In Response to 6.3.6.2
Reference Plan 6.4.6.4 REV 5
Property #44

Figure 15.3: Scheme Layout and Agricultural Layout Plan

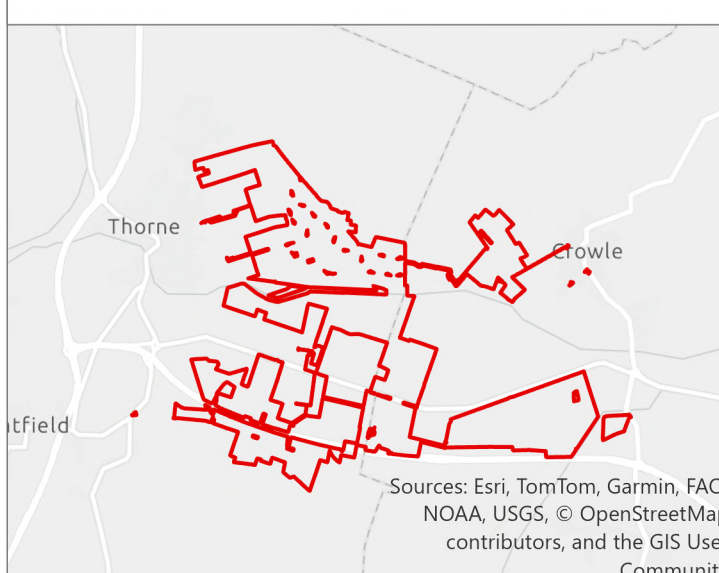
During the Examination hearing I did request removal of the panels to the south of Plains Lane (E20) duly noted thank you , as this provides a safe evacuation route on foot in the event of a fire

However my request to remove panels to the west of anchor drain (E 19) has not been met ? Given the proximity of the panels to my property and the prevailing south westerly / westerly winds and the tinder dry vegetation conditions of late, these form an unacceptable fire risk to my property and livelihood

I must now also request removal of panels from (E 2) to a minimum distance of 200 meters from my northern boundary , to form an effective fire break

Why 200 meters? 200 meters is Industry Standard Best Practice Advise except in EXEPTIONAL CIRCUMSTANCES?
